# WOODMOOR WATER AND SANITATION DISTRICT NO.1

## LAKE PUMP STATION NO. 2 AND TRANSMISSION PIPELINE

### GRADING AND EROSION CONTROL PLAN

Add text:  
PPR-21-019

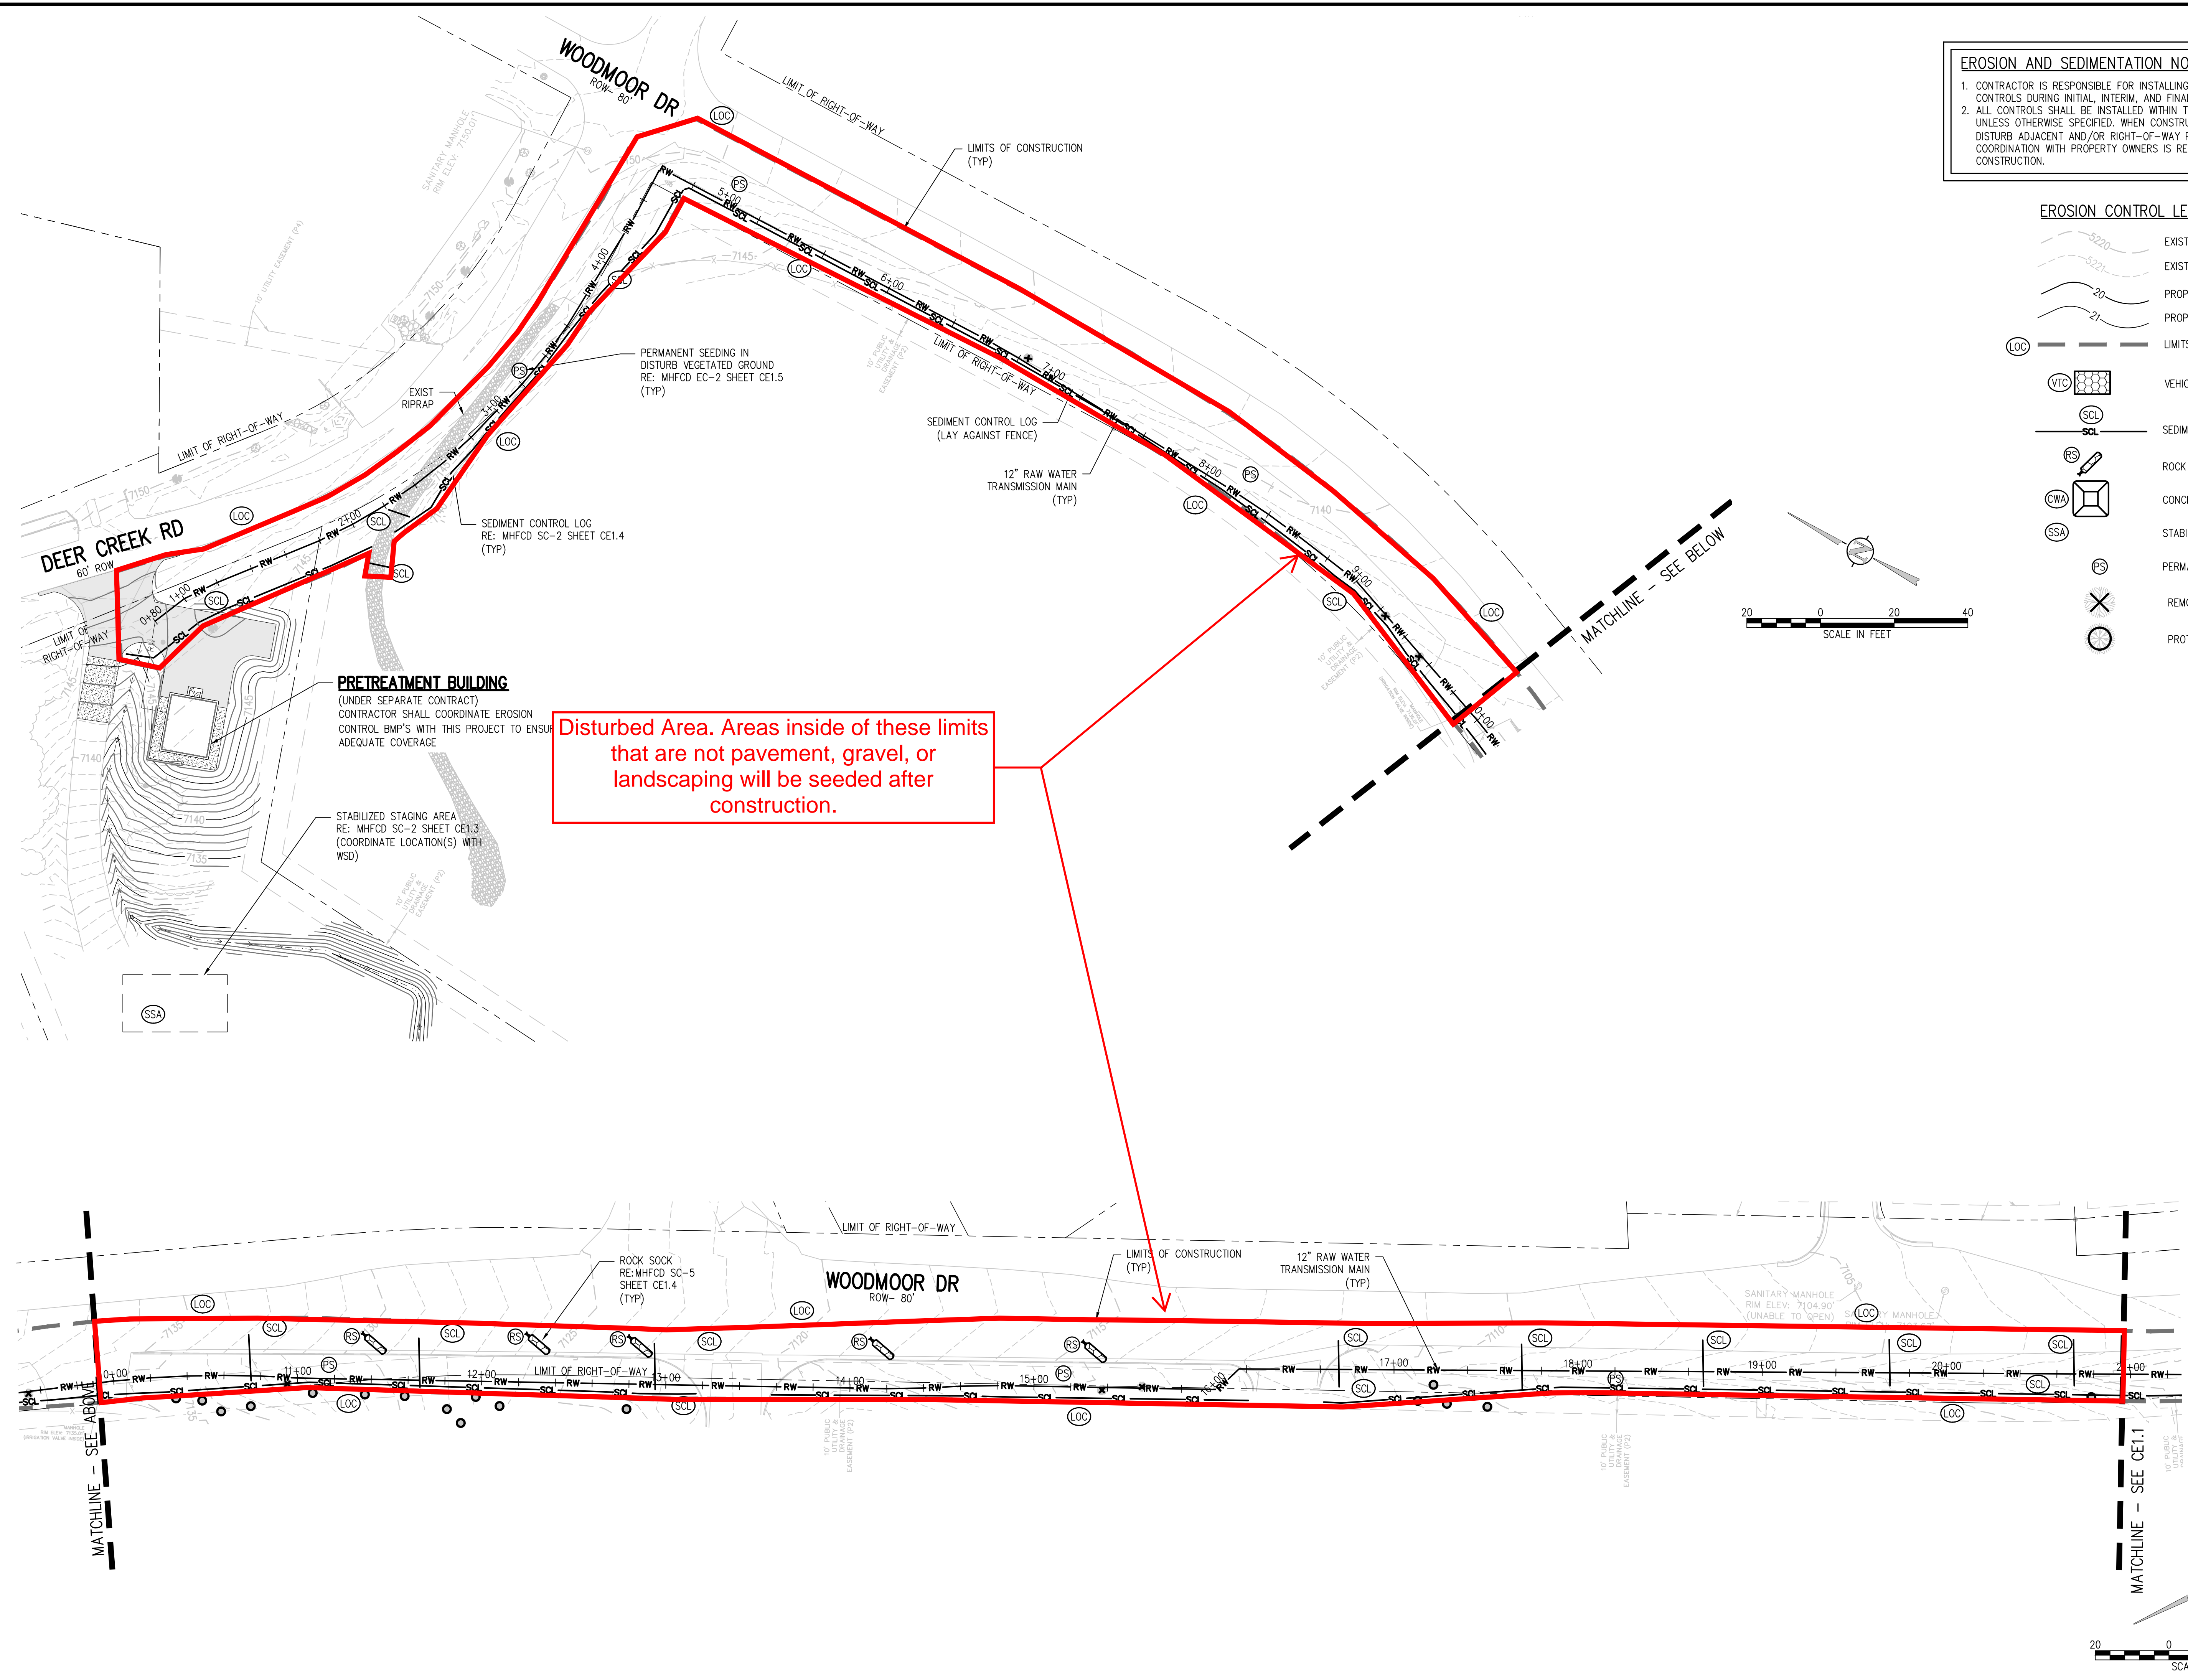
Provide a keymap

linework doesn't seem to match aerial photo.  
 Call out areas to be restriped and patched.

provide trench detail.  
 Provide pavement patch detail.  
 Show limits of pavement patch and rotomill along the RW.  
 NOTE: if the pavement patch extends to the wheel path then you must rotomill to the centerline of the road.

Label edge of asphalt.

Show a sediment control measure like rock check dams across roadside ditch at appropriate spacing. And update FAE form accordingly. Typical for all areas with roadside ditch within excavation area.

In private properties, adjust limits of construction so it's within the public utility easement. WWSD must obtain permission/temporary construction easement from the property owner if construction extends beyond the easement.

Identify any and all surface improvements that must be removed/replaced.  
 Identify the extents of removal & replacement

SHEET NO.
C1.1

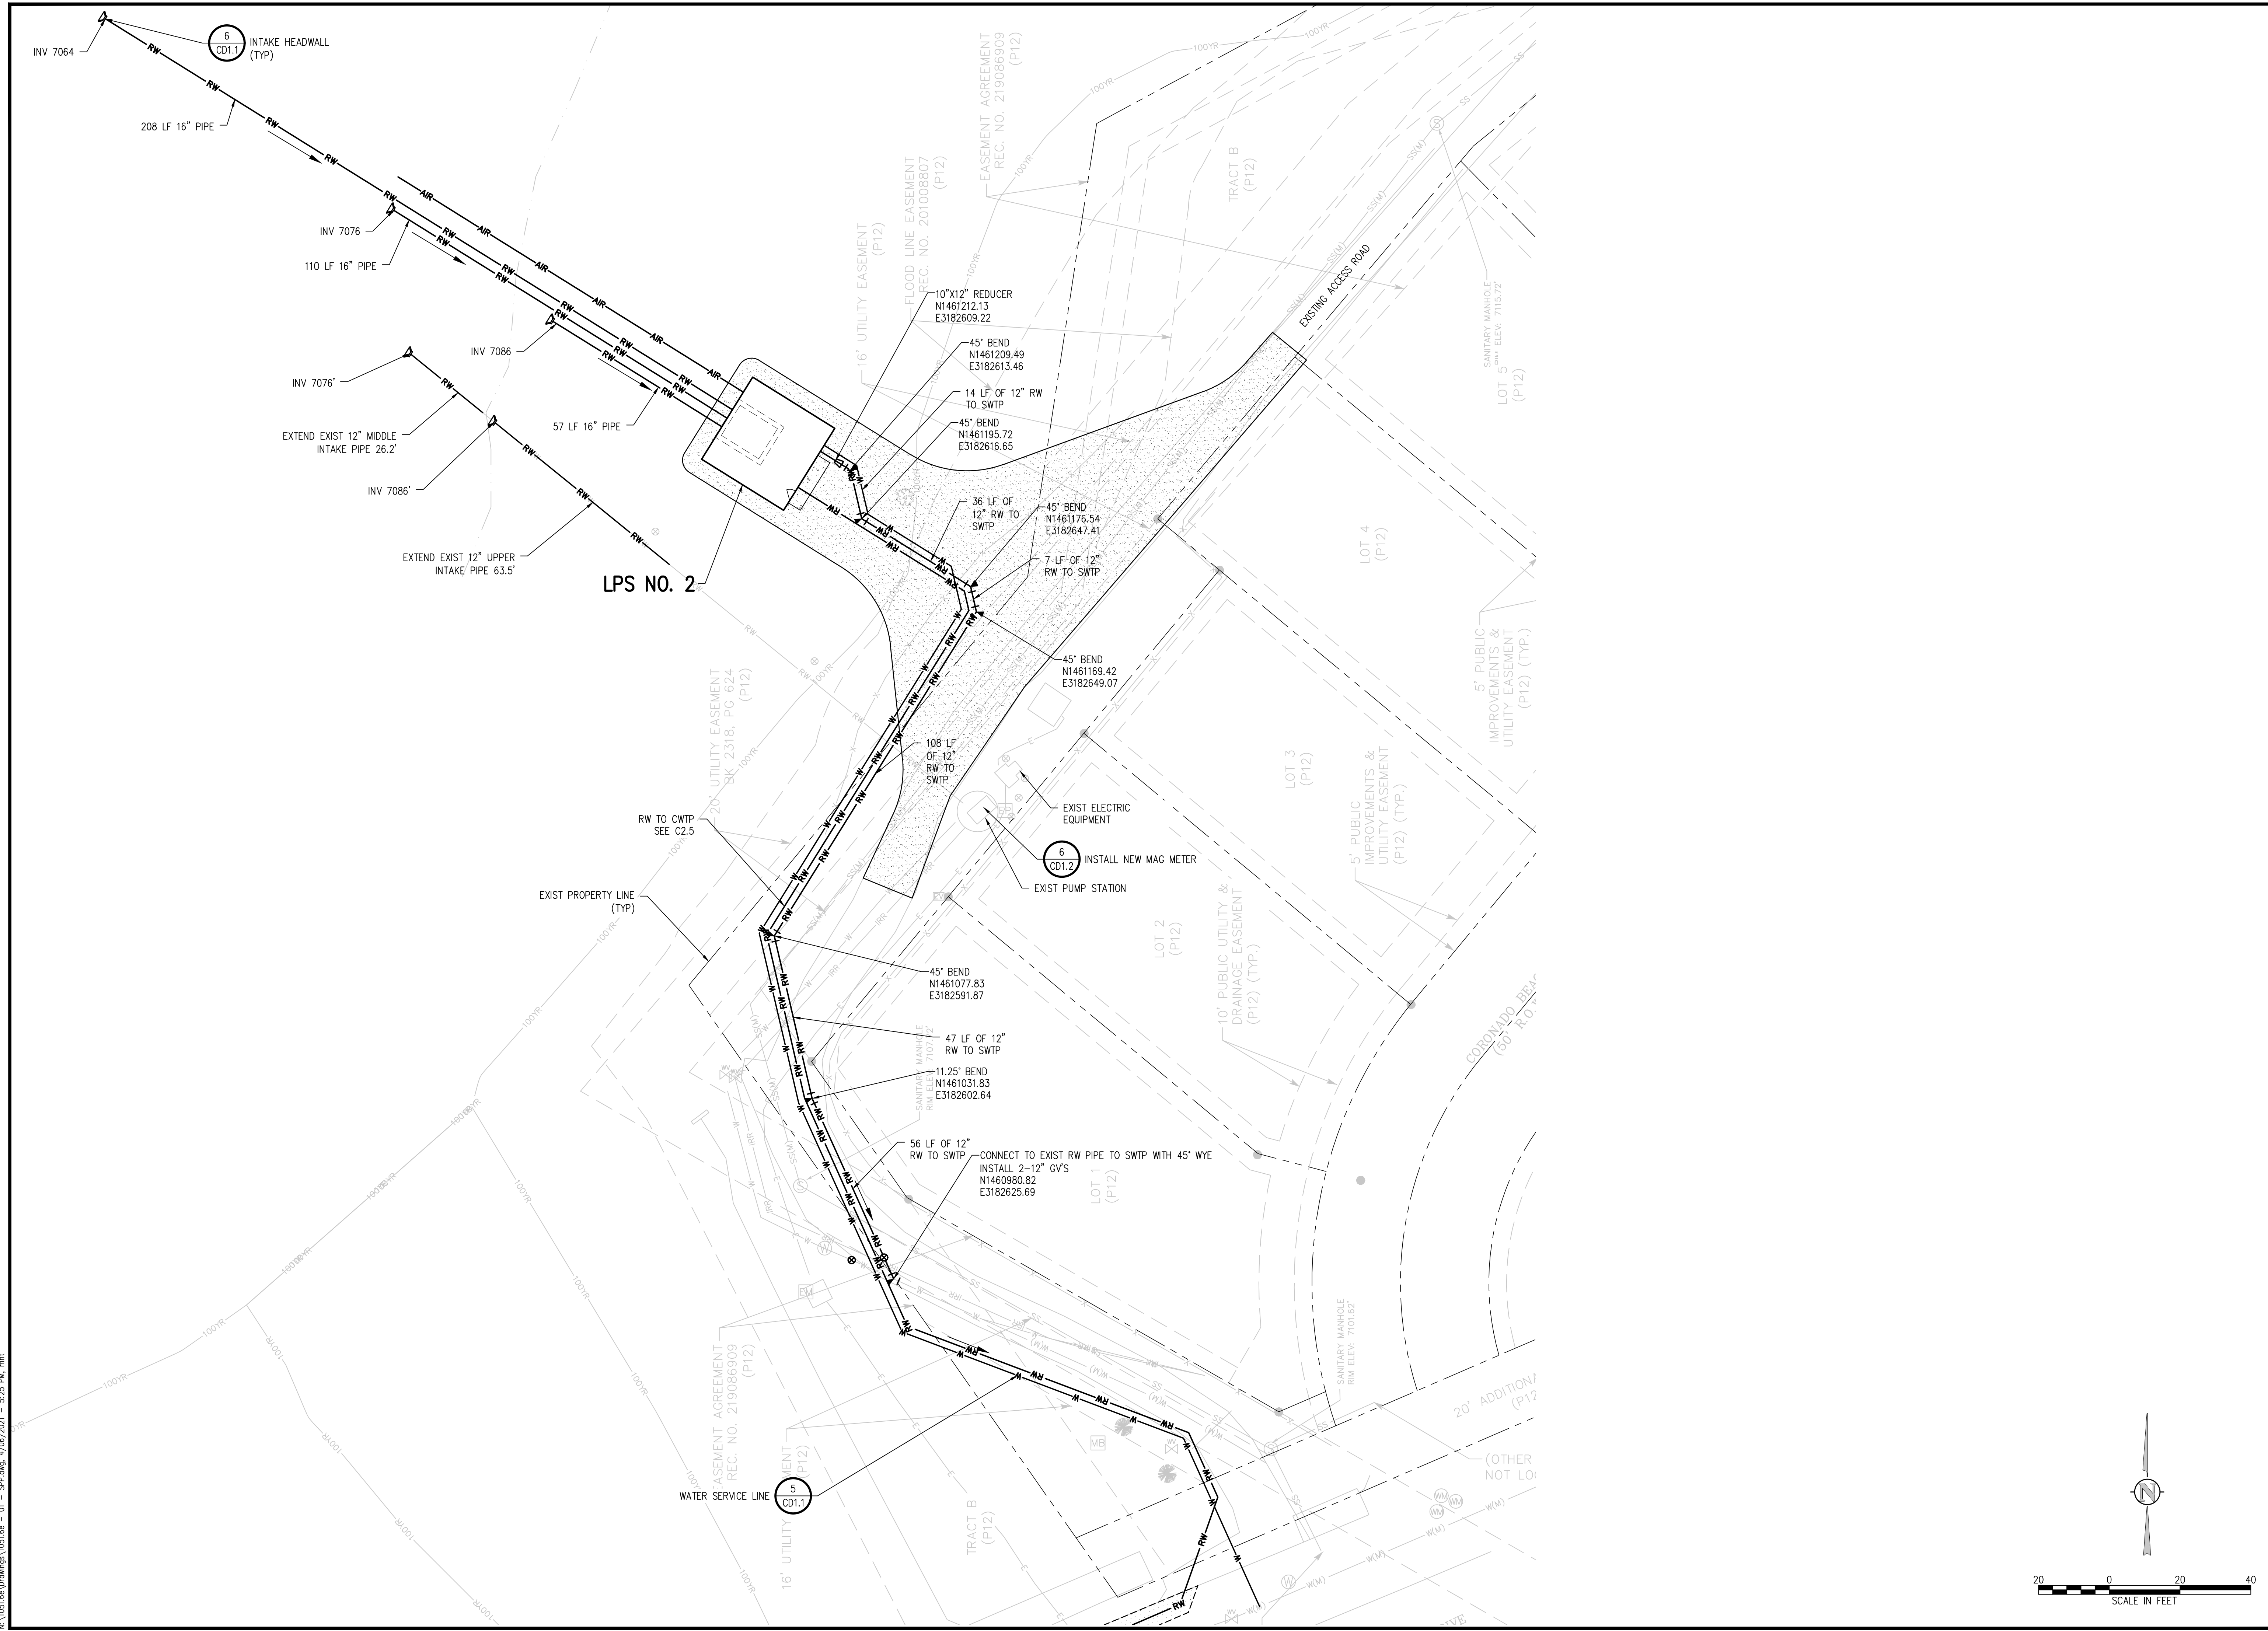
Specify riprap size/type and depth.

Update to label & show erosion control blanket per the standard EPC grading and erosion control plan note #15 on sheet 6 of 6.  
 Update the financial assurance estimate form to include the quantity.

Note that per details VT-1 and VT-2 in DCM Vol. 2, Chap 3.3, VTC should be 75ft min length. Shown here as 50ft. Revise.
